From: Bloomer, David <David.Bloomer@lancashire.gov.uk>
Sent: 07 May 2015 14:07
To: John Macholc
Cc: LHS Customer Service; planning
Subject: RE: Loud Bridge Chipping

Apologies for the delay I was waiting for comments from the police regarding the suitability of the route. These have now been received and on the basis of comments received and discussions with the applicants agent I would raise no objection to the proposal on highway grounds subject to the following conditions being attached to any permission that may be granted.

Project Details,
PROPOSED SITE PLANS

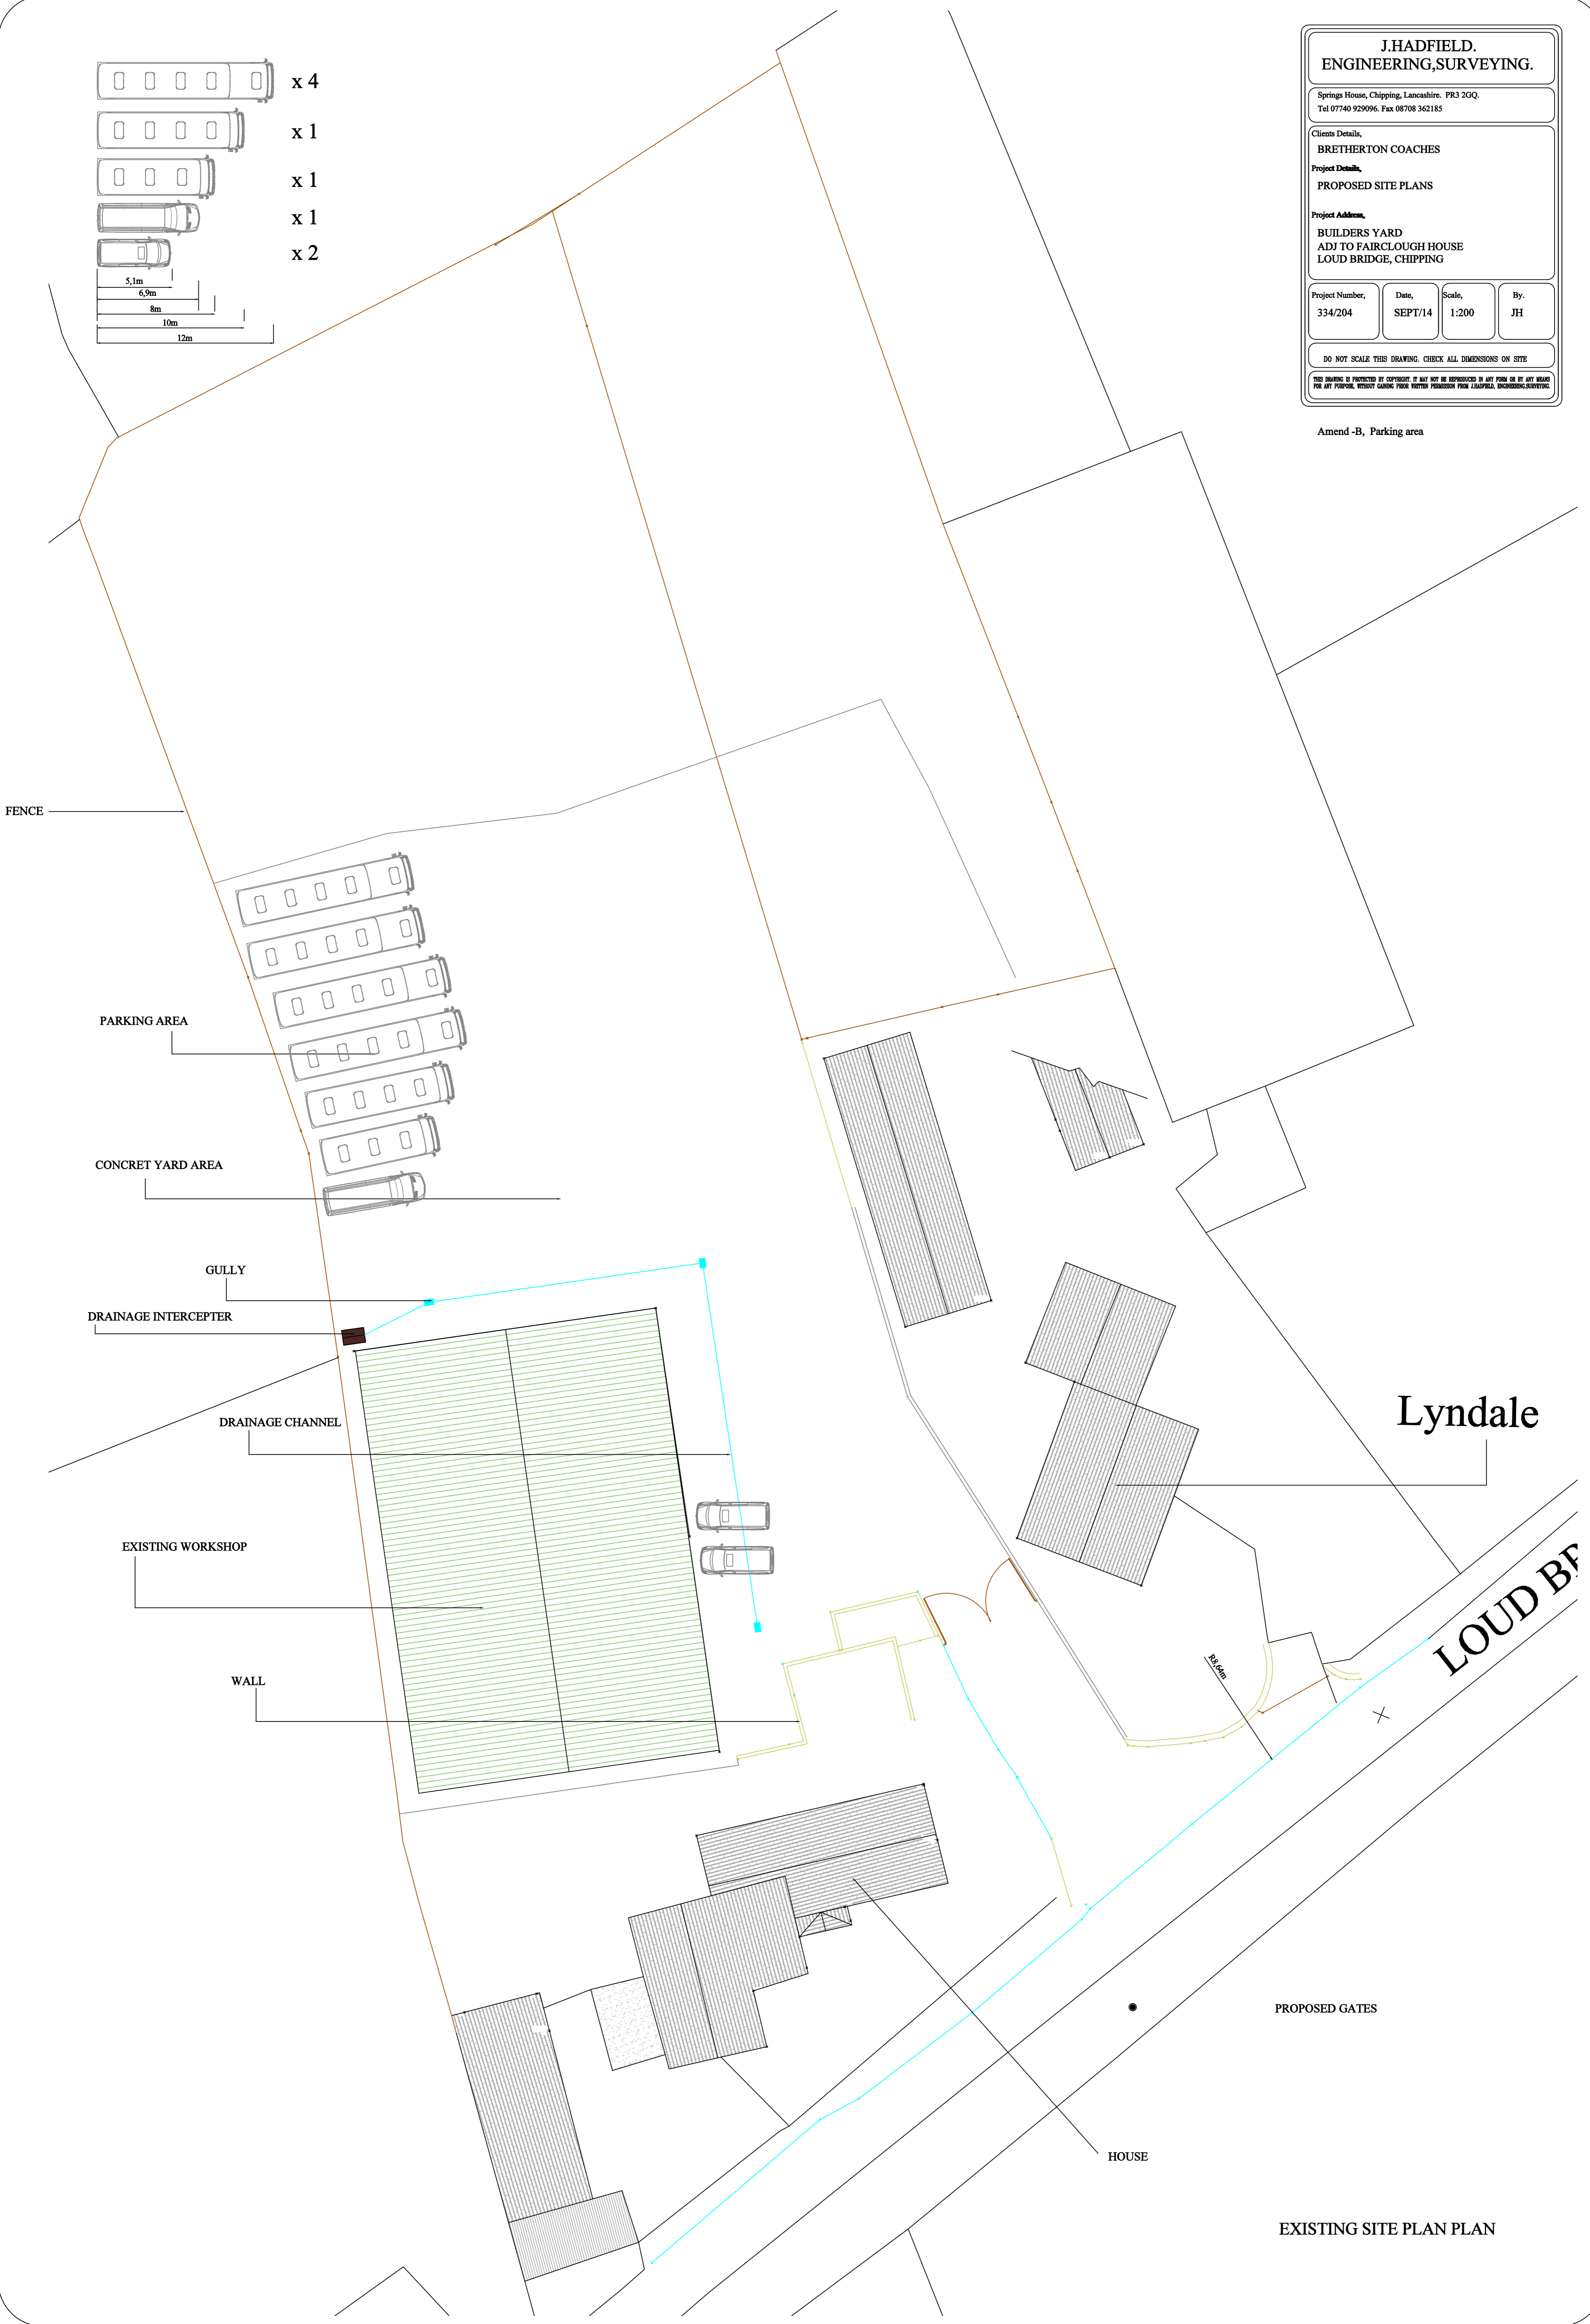
- 4 The parking shall be in accordance with the parking layout shown on the Parking Area Plan Amendment B submitted 17th April 2015 Reason to ensure efficient use of the site
